TOPOGRAPHIC – SITE PLAN MAP

ADDRESS:
5675 BLUE BELL LANE
COLORADO SPRINGS, COLORADO 80908

SFD24616

Plan Track #: 189354

BASEMENT FLOOR PLAN

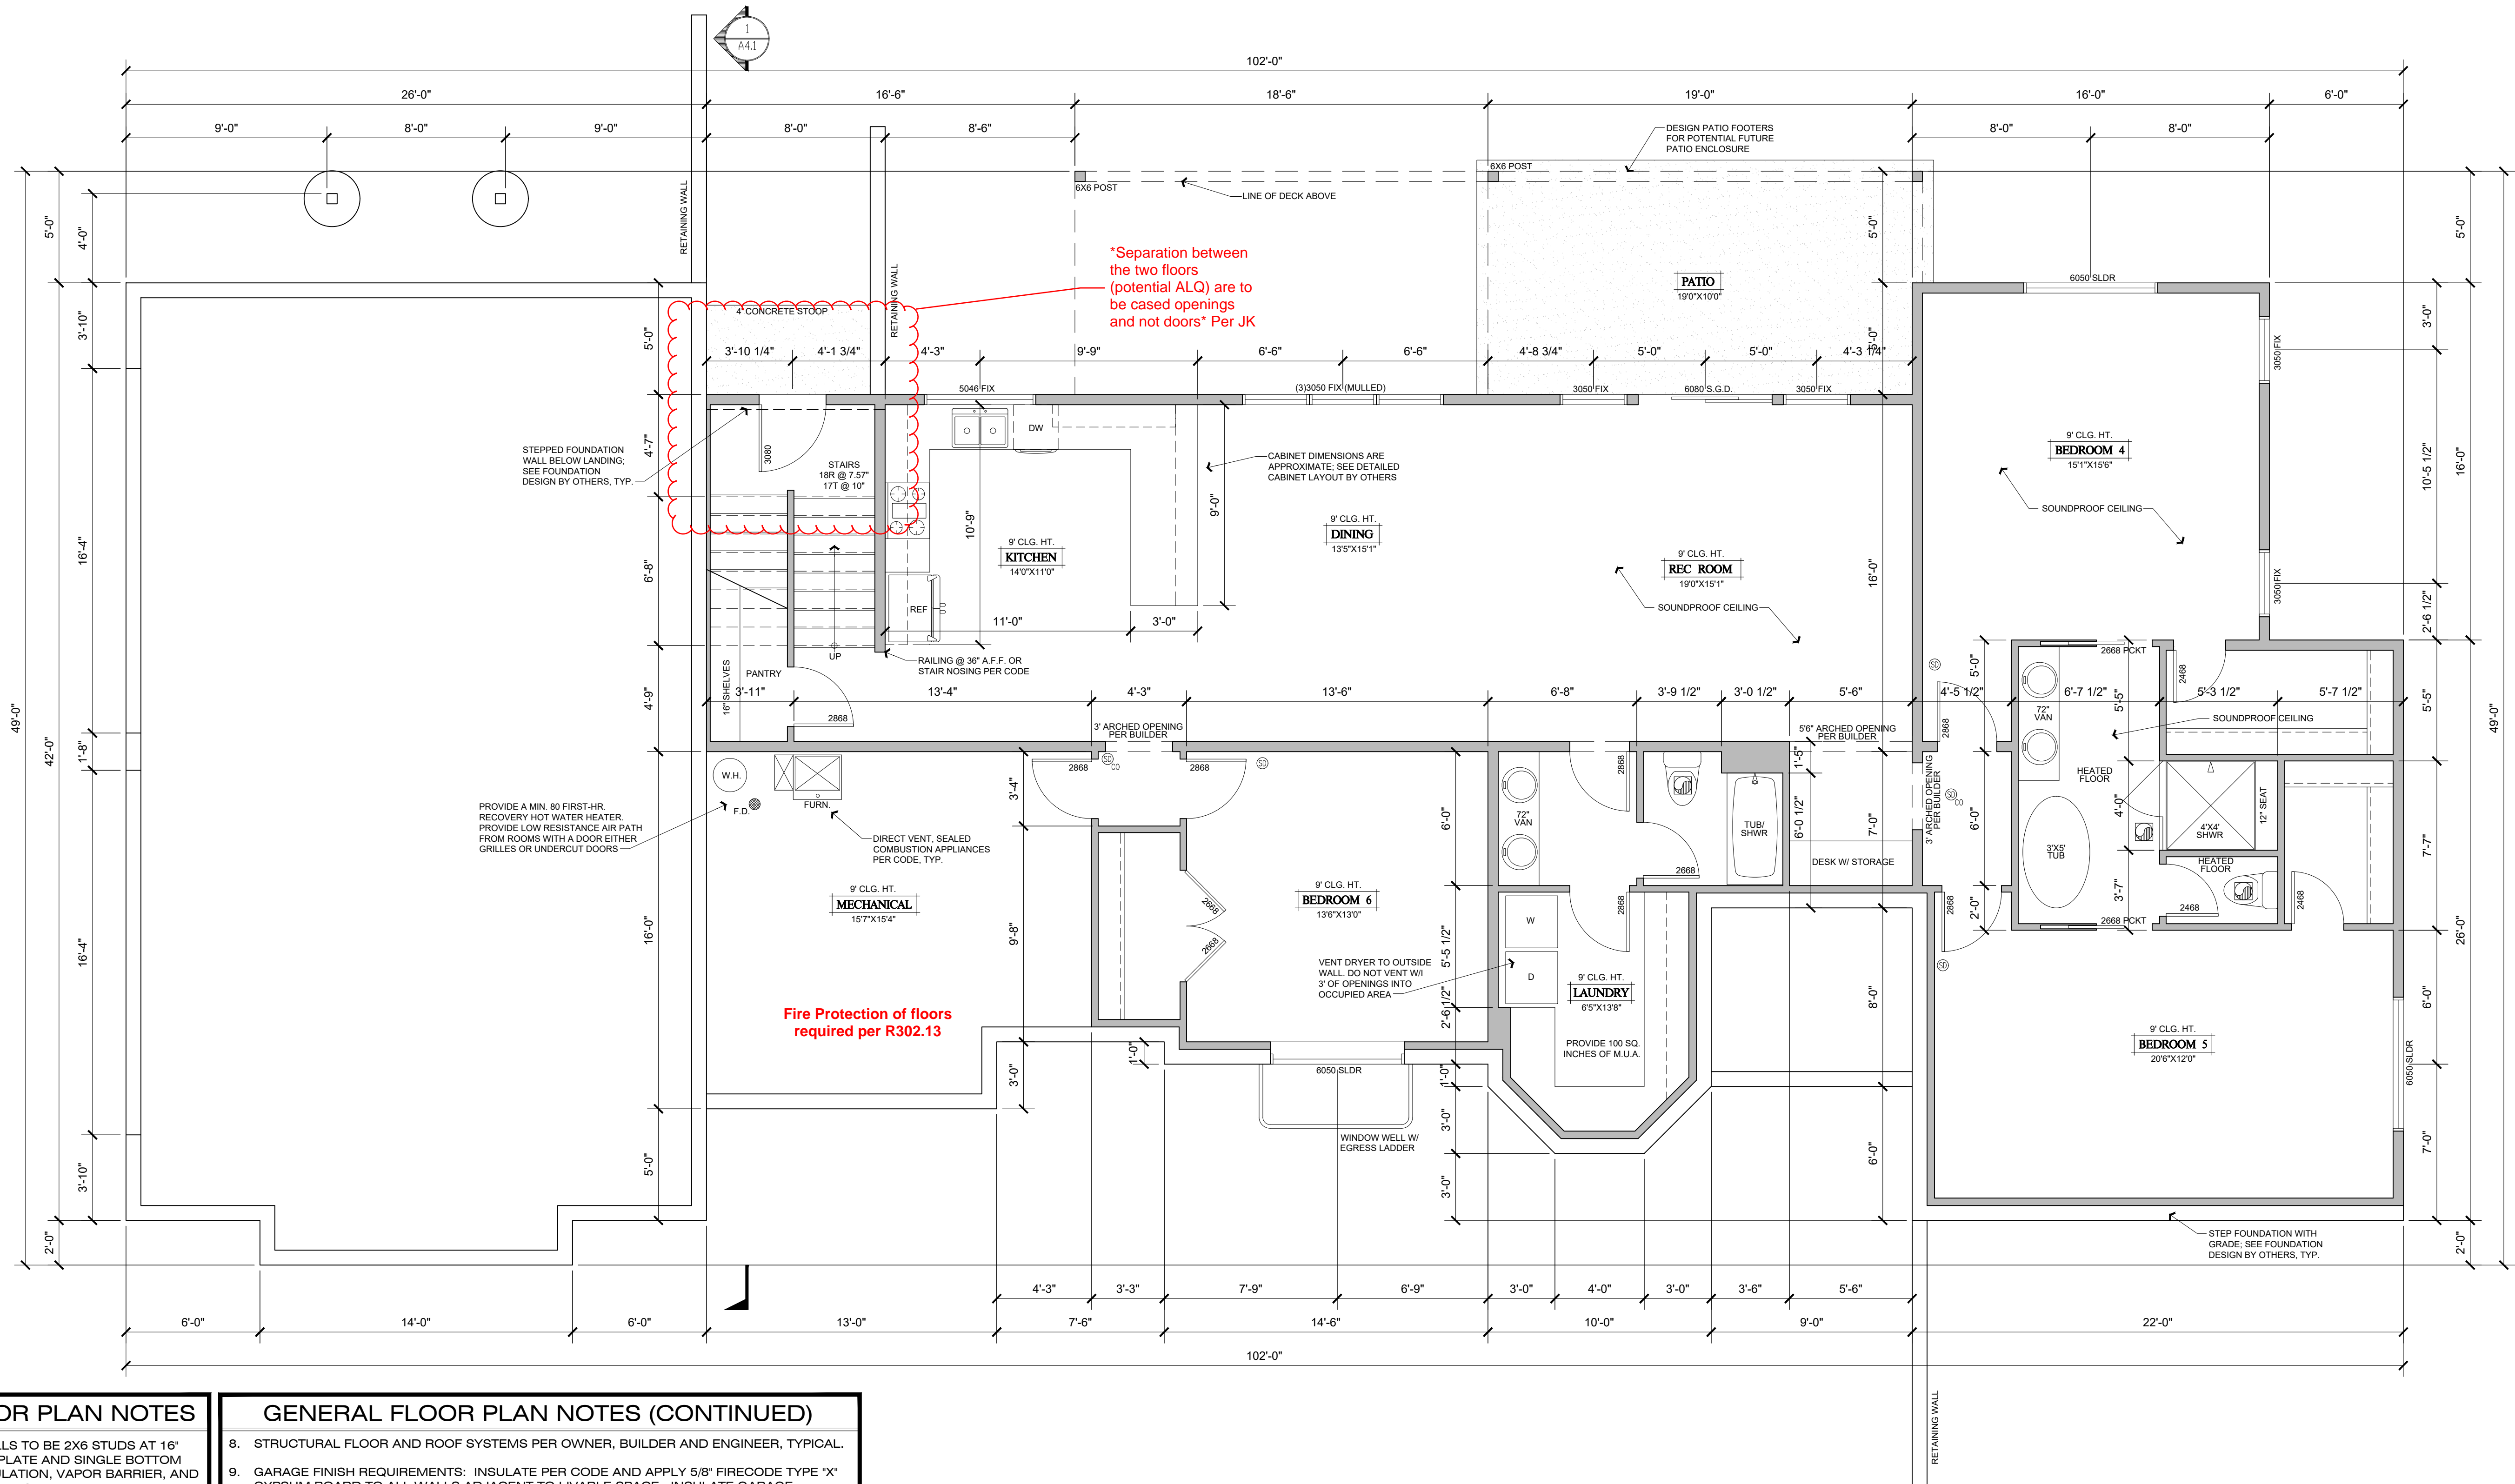
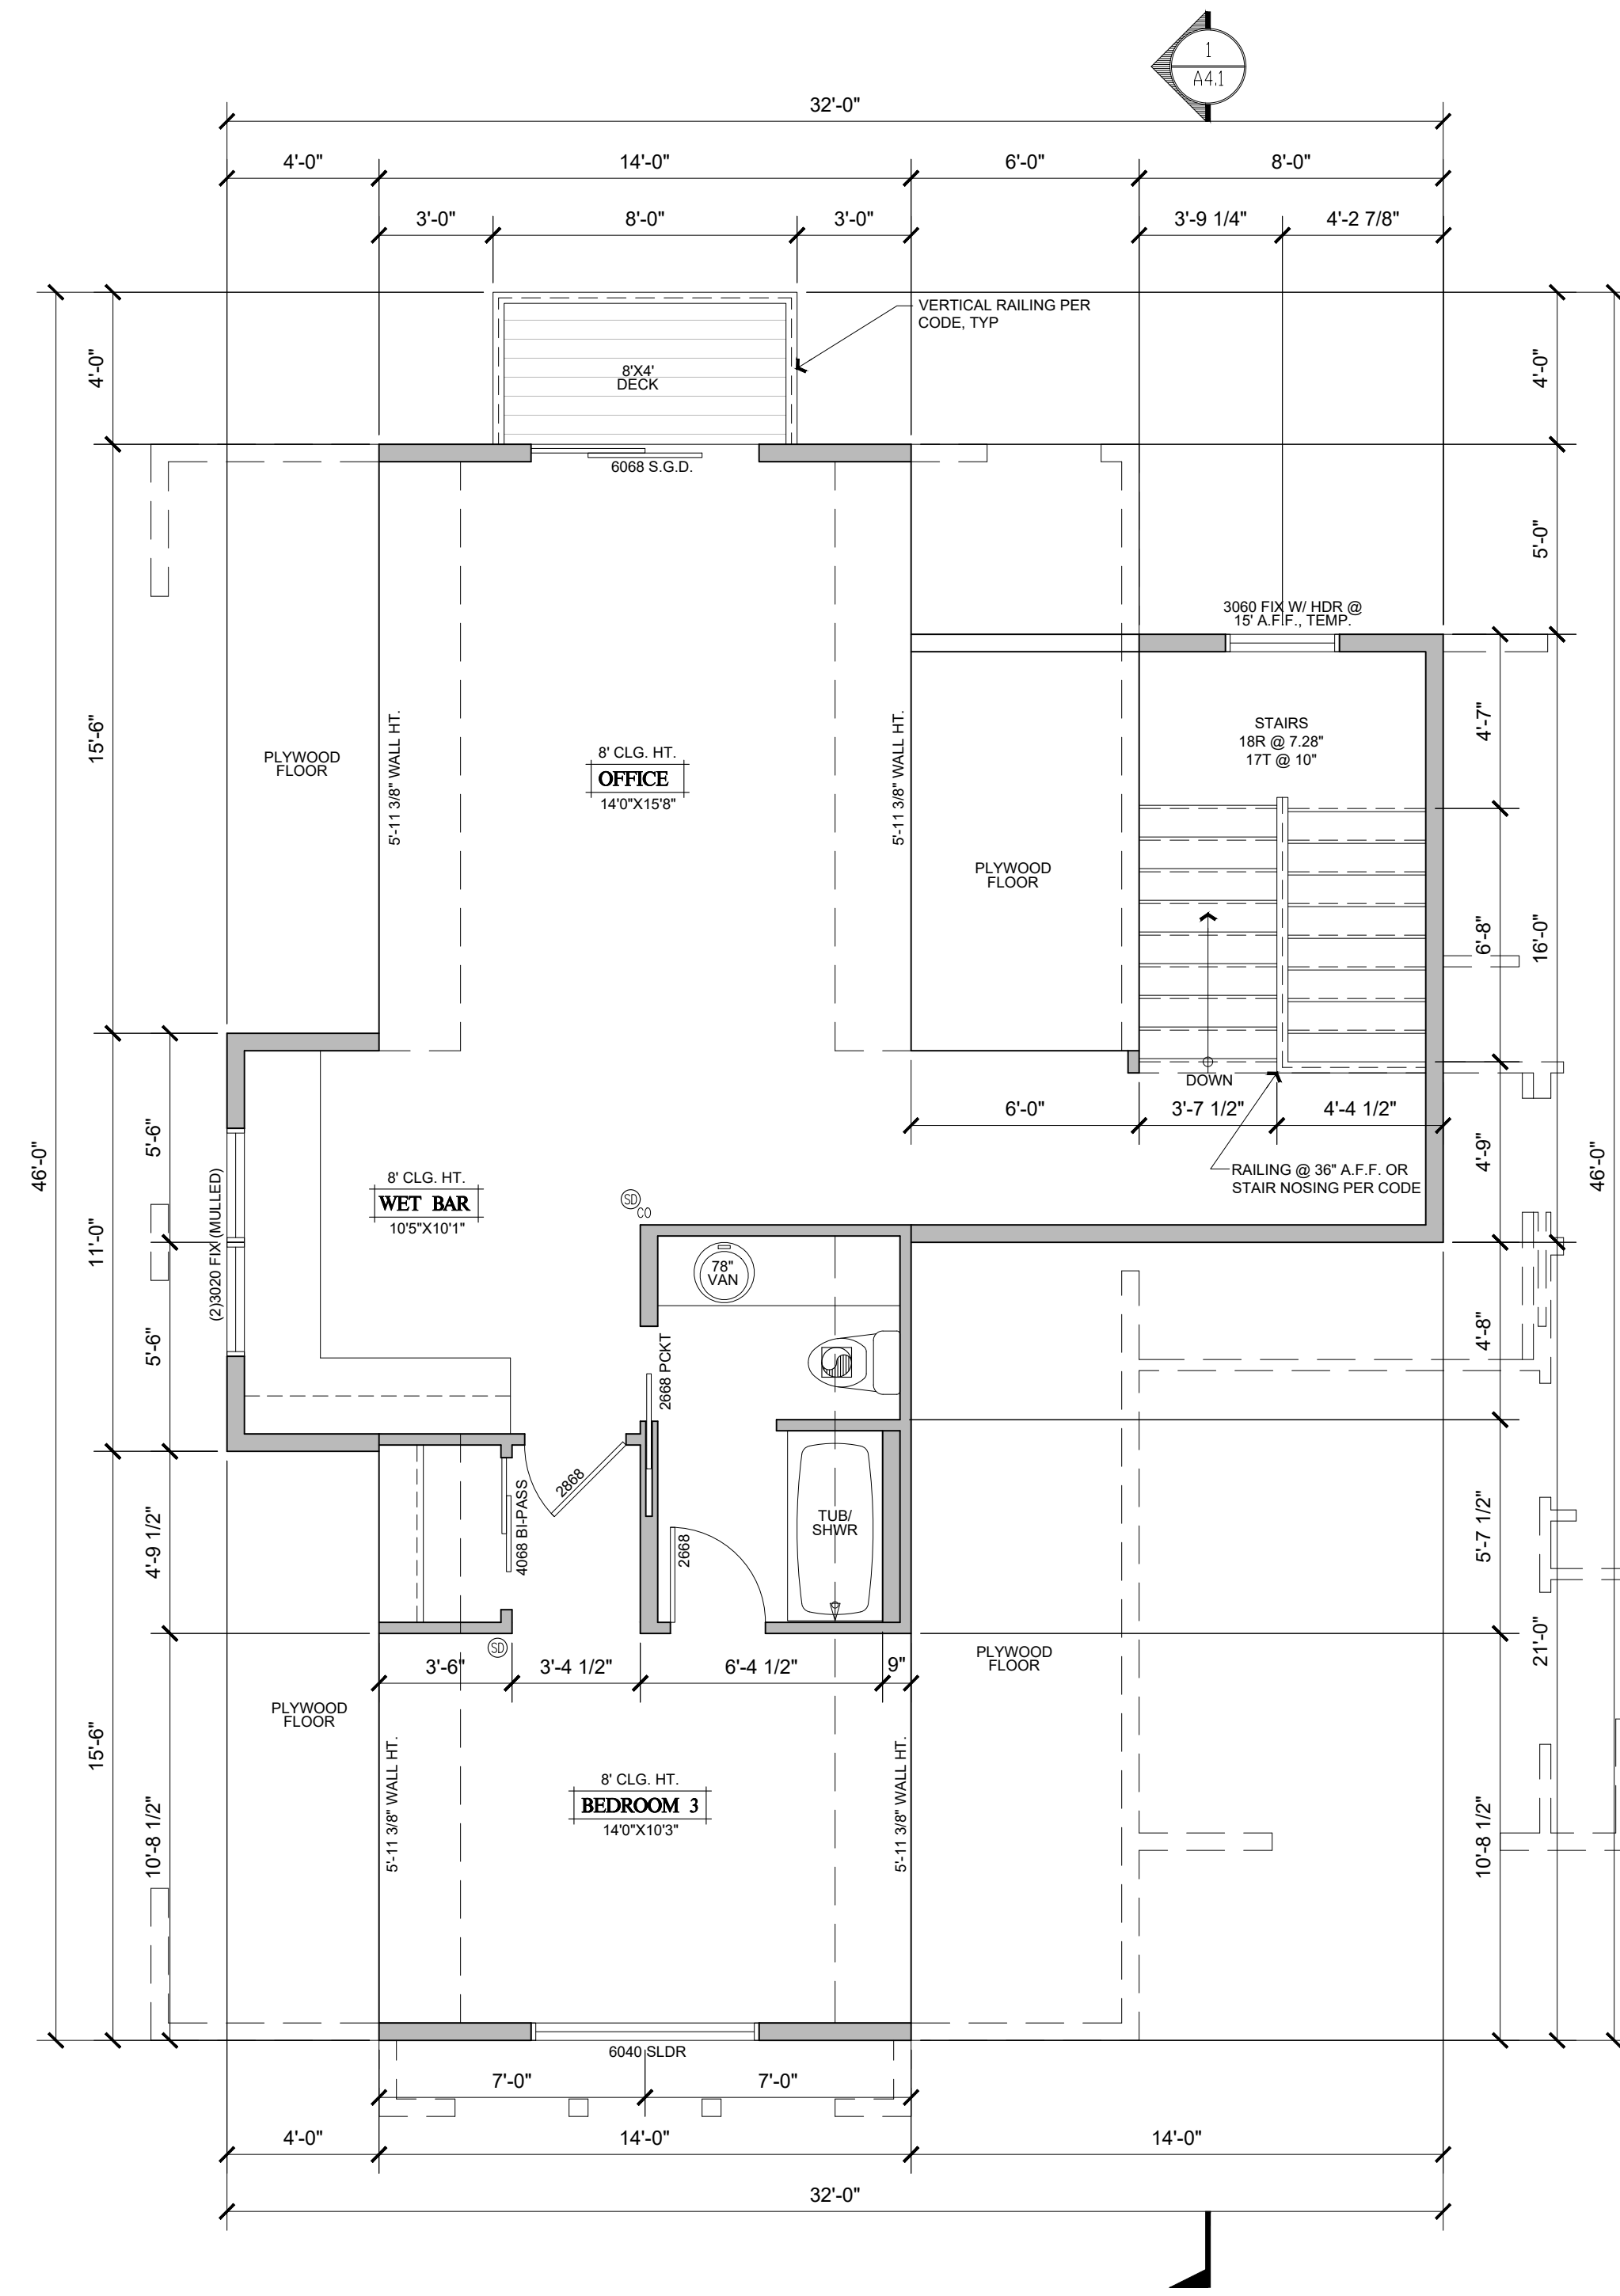
***Separation between the two floors (potential ALQ) are to be cased openings and not doors*
Per JK**
